Consultation Response from KC Waste Strategy (Refuse & Cleansing)		
PA no. & address: 2021/91871 - Land adj, High Street and Challenge Way, Hanging Heaton, Batley		
Proposal: Erection of residential development (55 dwellings) including access and associated infrastructure REVISED PLANS		
Date Responded: 21/07/2021	Responding Officer: Carol Oakden	Responding Ref: WPN-21-008R1

Original comments (27/05/2021) with further comments on revised layout plan (drawing number 301 Rev11) highlighted:

Public Open Space
Amenity Green Space
802sqm

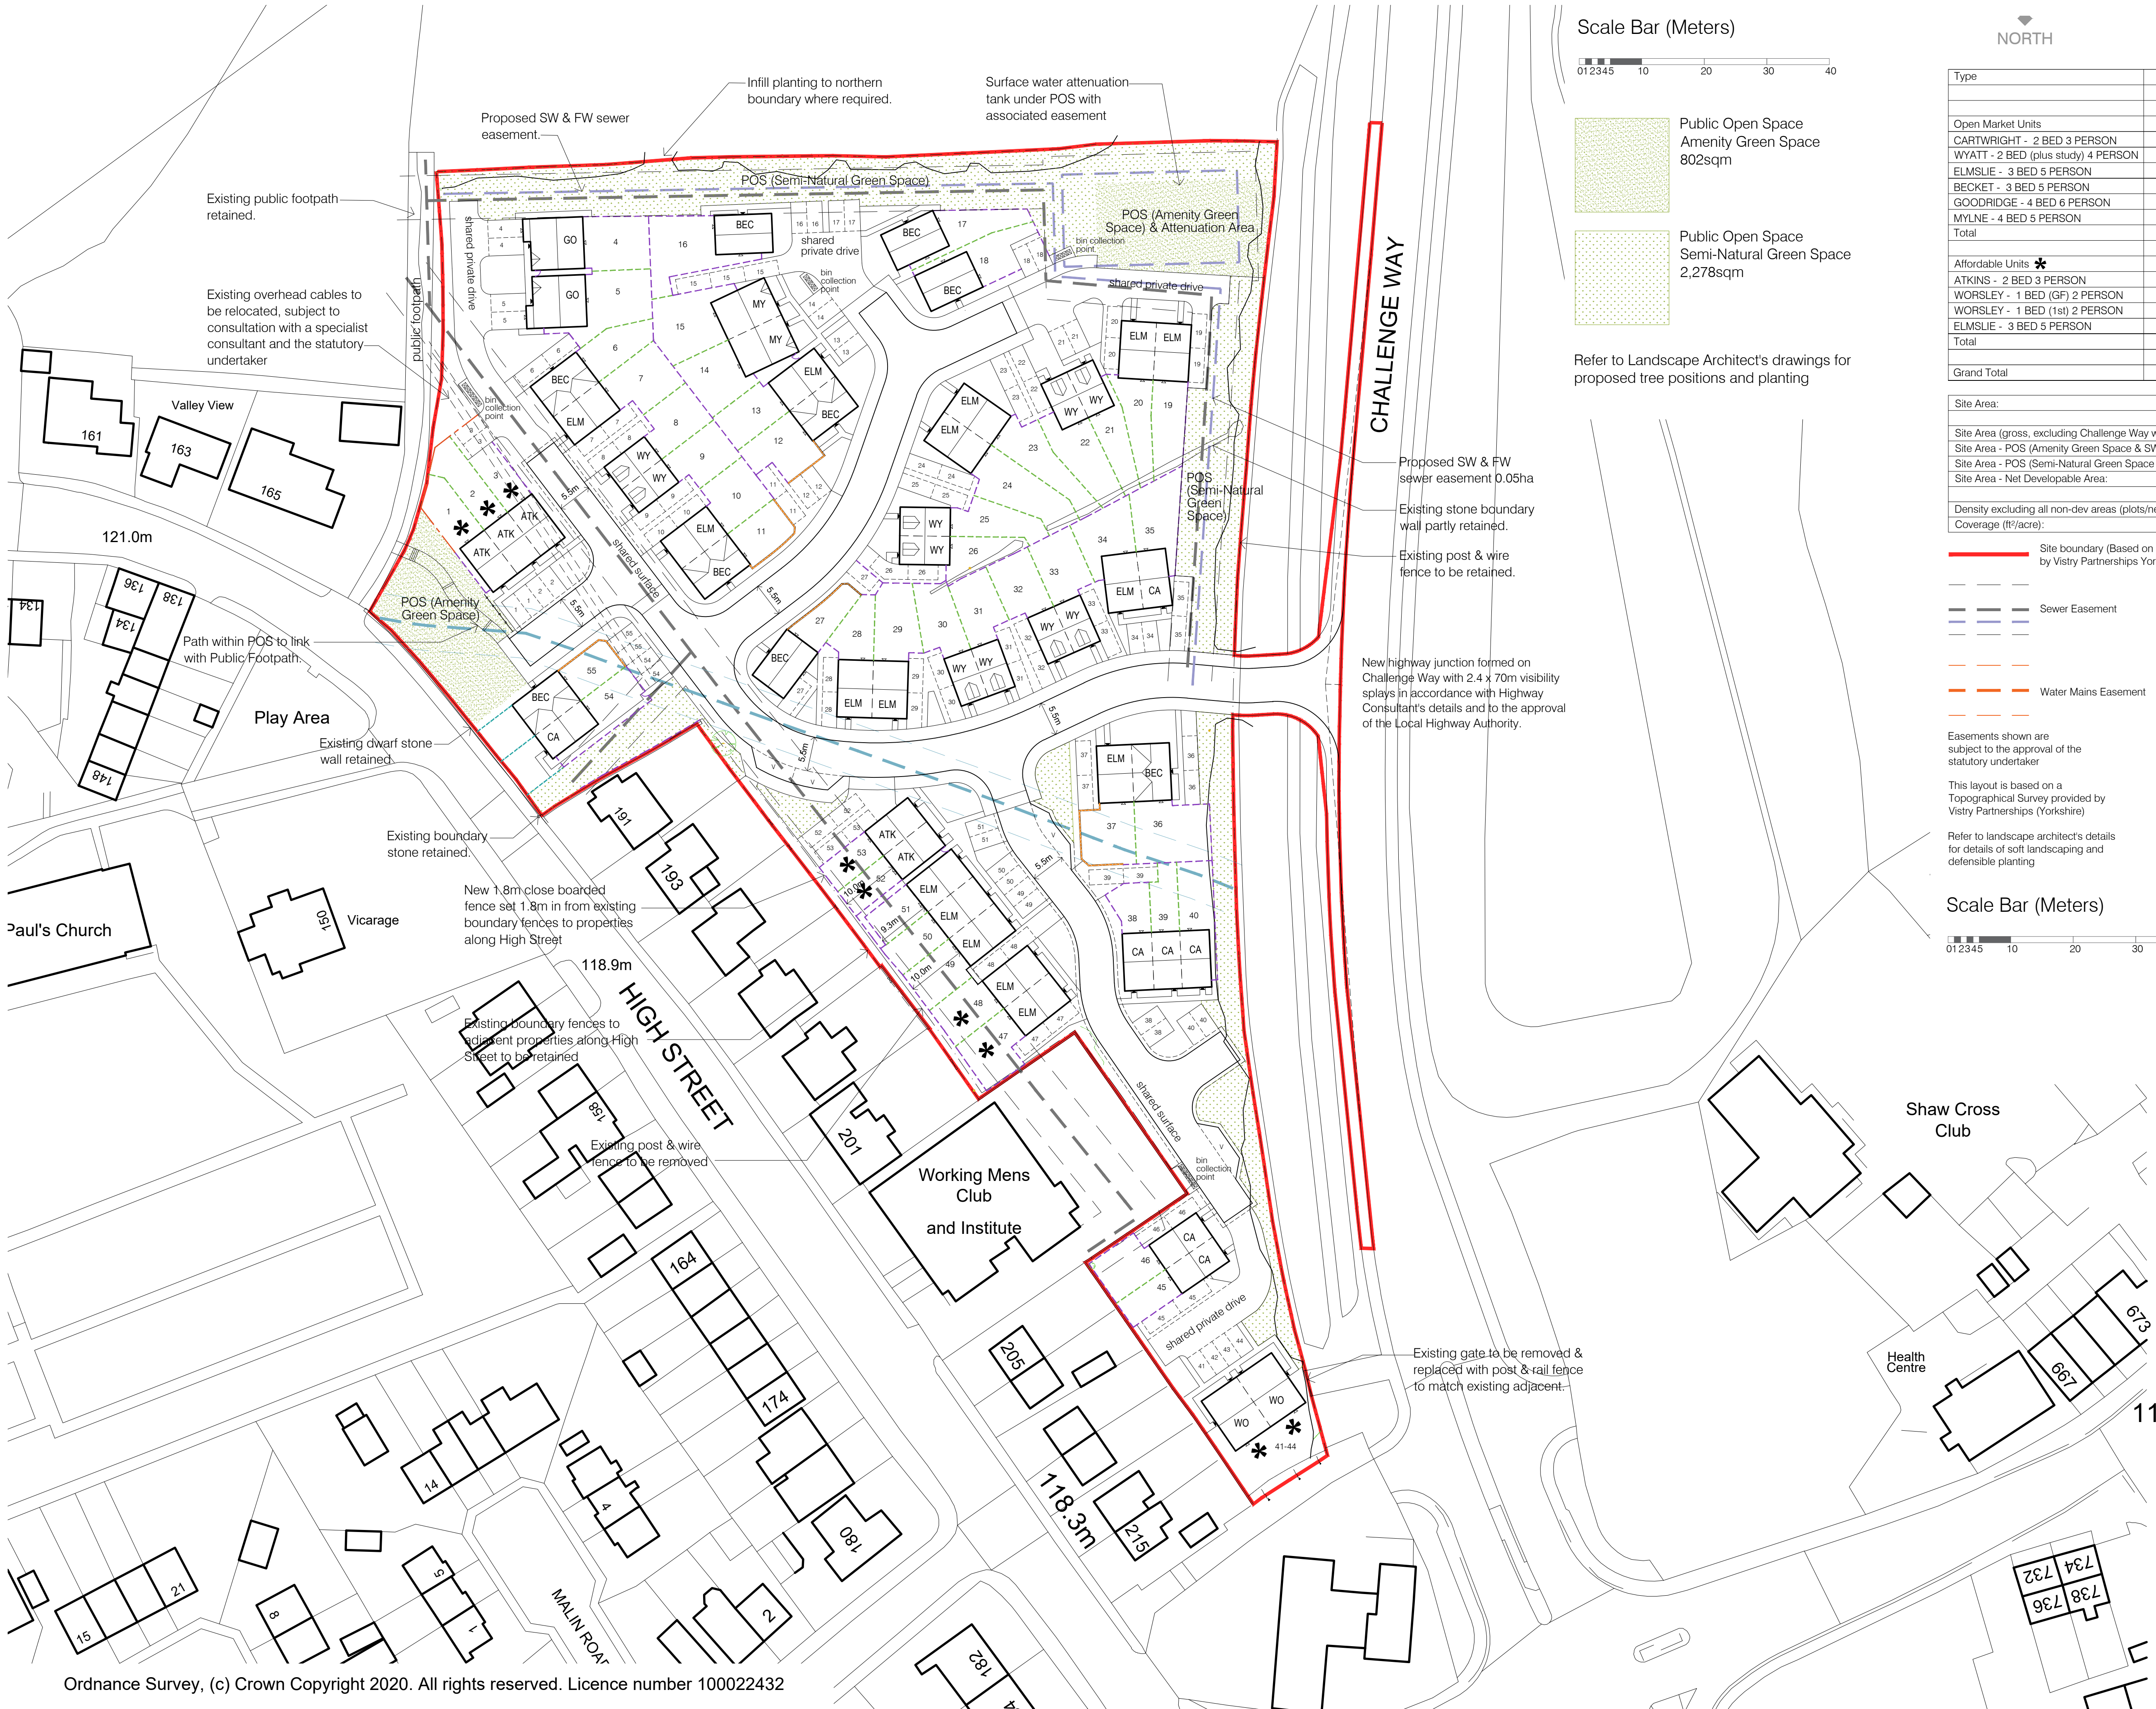
- Communal bin presentation points have been identified for most of the private shared driveways except for plots 15-18 which needs adding. ***This has been added and is acceptable.***

- The communal collection point for plots 41 to 45 needs to be closer to the adopted highway to reduce the drag distances for collection crews. ***This has been moved to a suitable location and the amended layout/house types on this private shared drive allow for better external space and therefore bin storage options.***

- Some of the communal presentation points appear to be shown as grassed areas which are unsuitable. These should be level, hard surfaces that cannot be damaged by bin wheels or result in muddy trails from moving bins on grass in inclement weather. ***These now all appear to be hard surfaced.***

- The submitted swept path drawings do not account for the potential locations of parked cars on the street – for example along the rear elevation of the neighbouring Working Mens Club site which would impact on the viability of the turning head for an RCV;

- There appears to be very little visitor parking to help alleviate any potential on-street parking issues. ***Some visitor parking has been added. The swept path demonstrates that a parked vehicle along the WMC rear elevation would prevent the turning area being useable for an RCV, most likely resulting in a long reverse manoeuvre. The inclusion of visitor parking specifically along this shared surface road is important in helping to prevent such parking.***
